Arun District Council
Arun Civic Centre
Maltravers Road
Littlehampton
West Sussex BN17 5LF
Planning General Enquiries
Tel: (01903) 737756 Fax: (01903) 730442
Dx: 57406 Littlehampton
Minicom: 01903 732765
e-mail: planning@arun.gov.uk
website: www.arun.gov.uk/planning

25 October 2018

Town & Country Planning Act 1990 (as amended)
Town and Country Planning (Development Management Procedure) (England) Order 2015
Application for approval of details reserved by condition imposed under planning permission
BN/7/18/PL relating to condition No. 3 (proposed surface water drainage), 4 (Discharge of
watercourse) & 5 (Surface water drainage system)
Land to the north of The Flint Barn Yapton Road, Barnham,

Engineers Comments Regarding Conditions 3, 4 and 5

Drawing:
Drainage Strategy

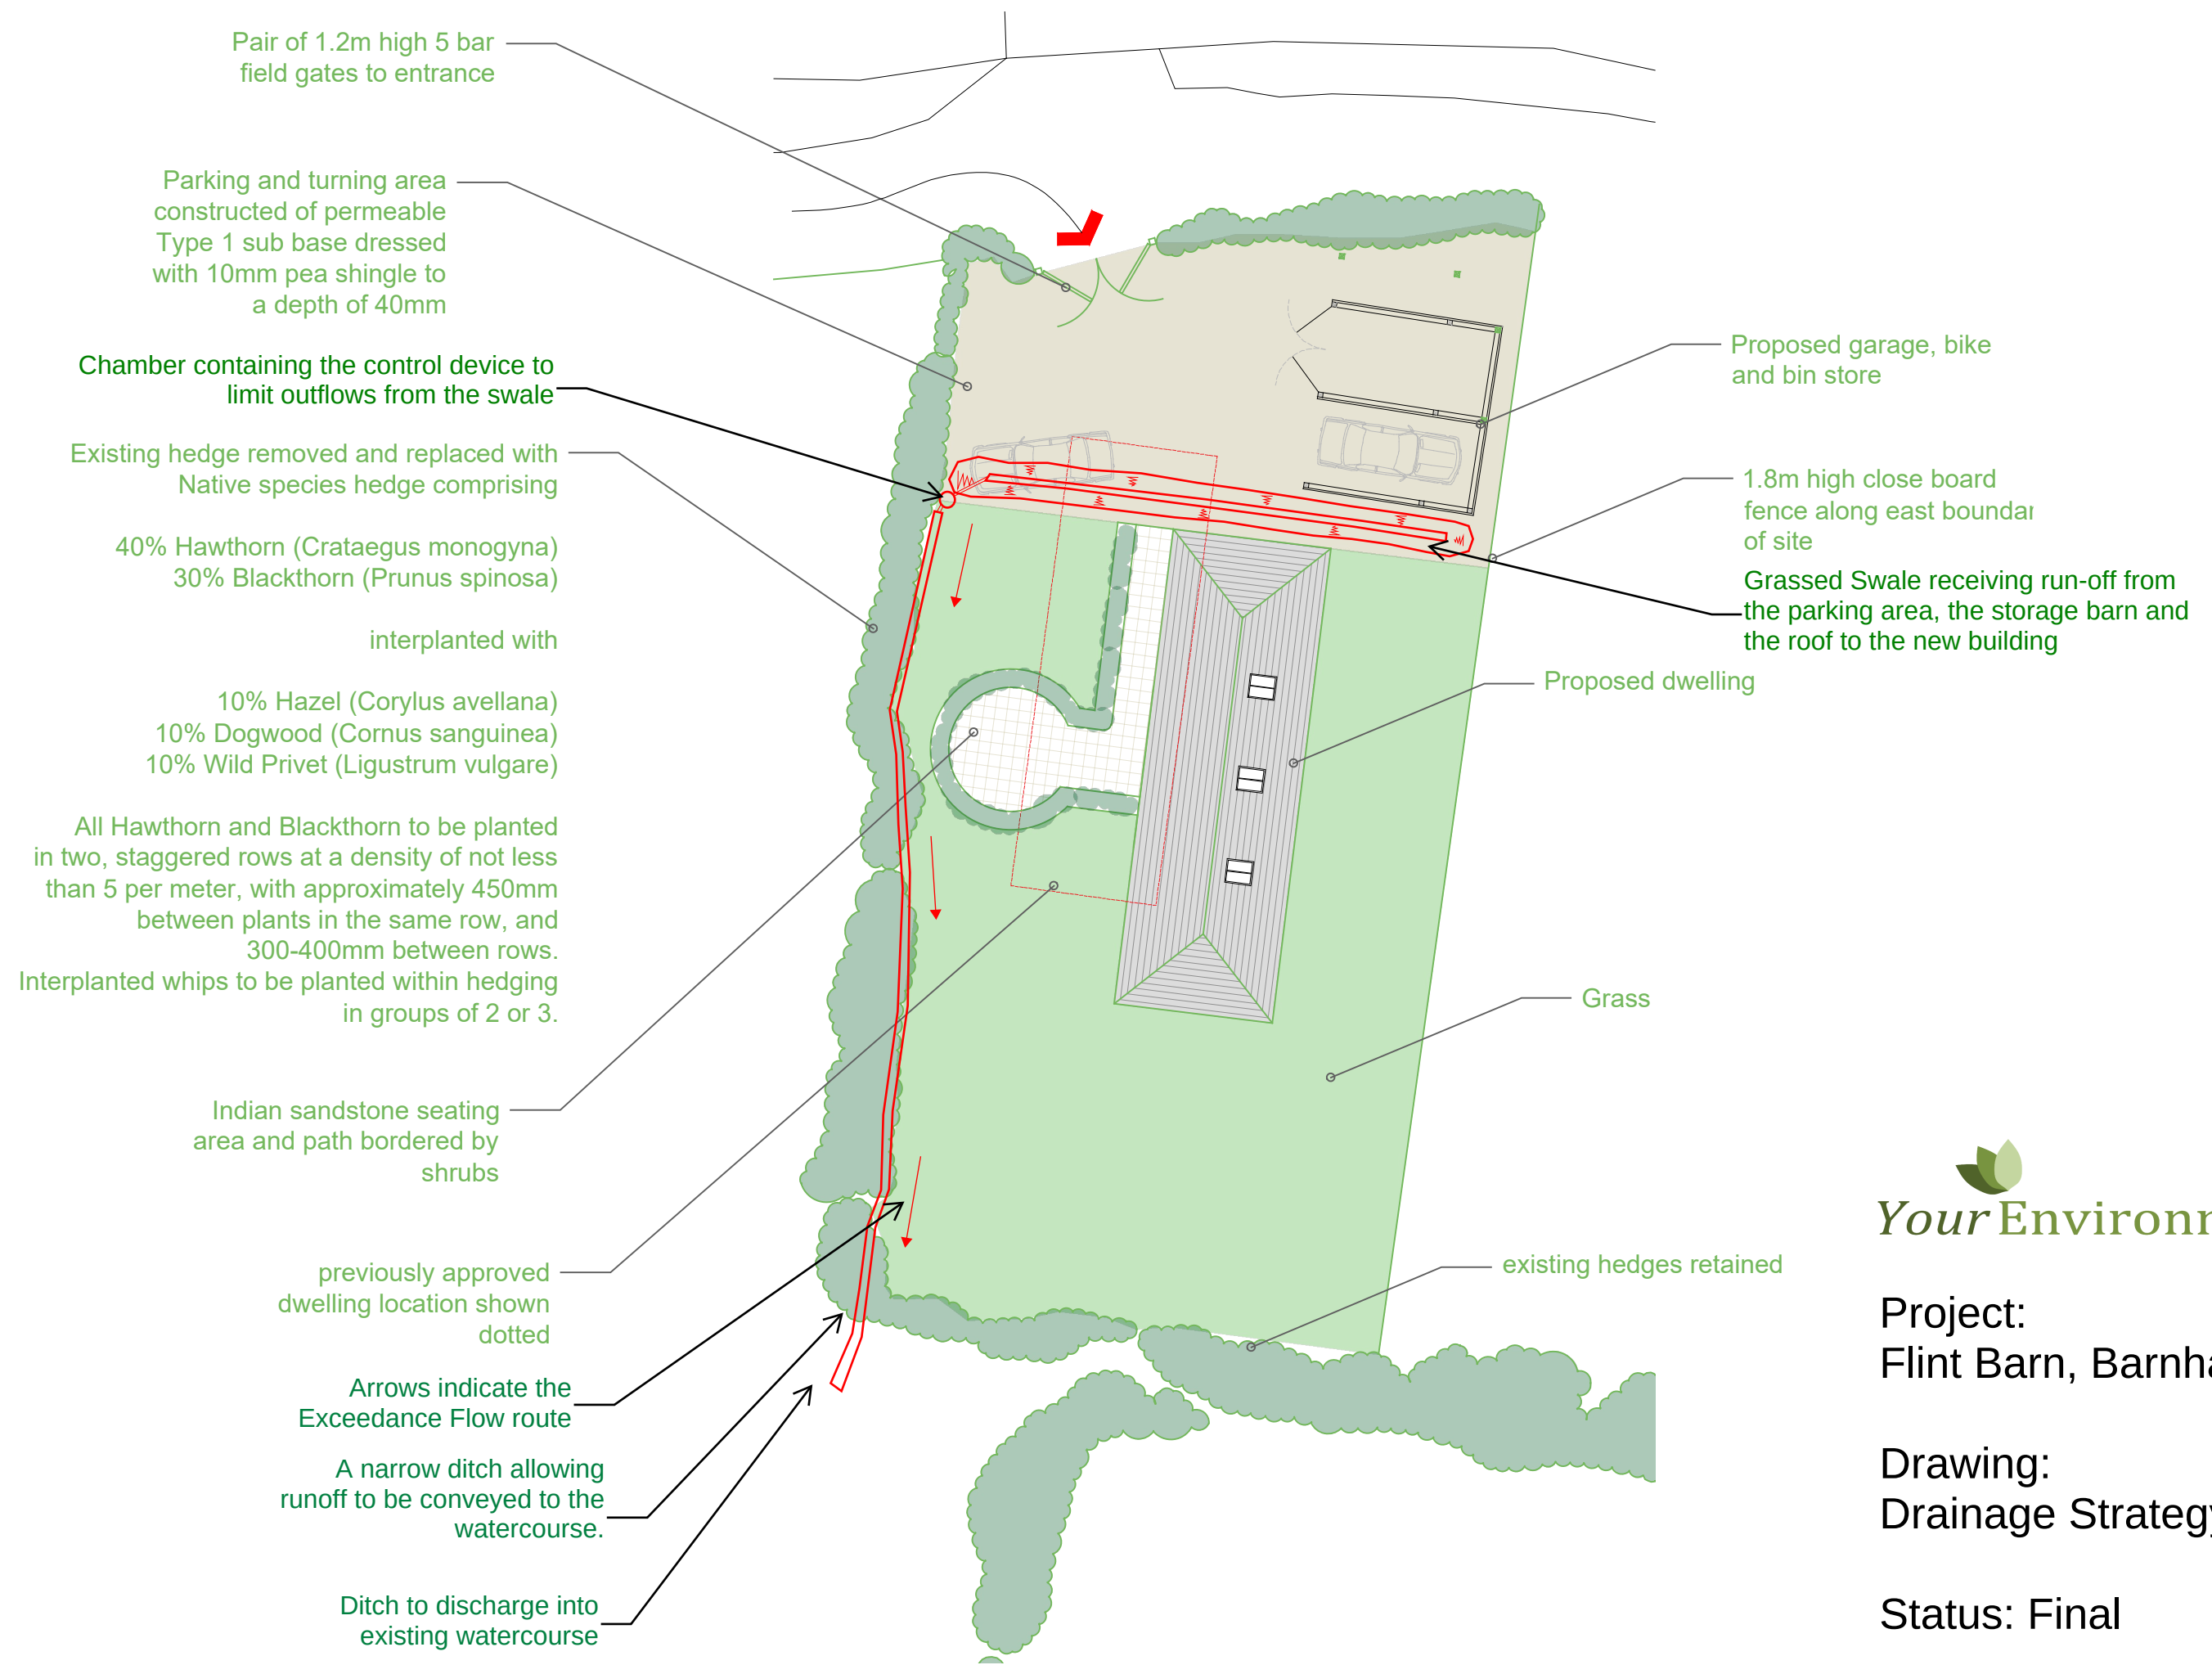
The applicant proposes to form a new swale and connect this into an existing ditch which runs to the south of the site. Winter groundwater monitoring was completed in March, which found

ground water levels to be high. We believe groundwater would have peaked before March, therefore may be higher than those levels recorded and we agree with the conclusion that infiltration is unlikely to be viable. However, the applicant may wish to investigate shallow permeable paving solutions. The proposals currently include for the storage of the 1 in 30 year rainfall event on site. Please revise the plans to accommodate the 1 in 100 year plus 40% climate change event on site. Please also clarify the rate of discharge proposed, orifice diameters have only been provided. In order to discharge flows to an ordinary watercourse the applicant will need to obtain Ordinary Watercourse Land Drainage Consent (the consent forms will be forwarded separately). I have inspected the watercourse which the applicant proposes on discharging into, it is heavily overgrown. The condition of this watercourse will need to be improved to ensure that flow can be conveyed downstream. The watercourse is culverted and runs under Yapton Road, the condition of this may also need to be reviewed.

Until such a time as consent is obtained and the above points are addressed I do not recommend that these conditions are discharged.
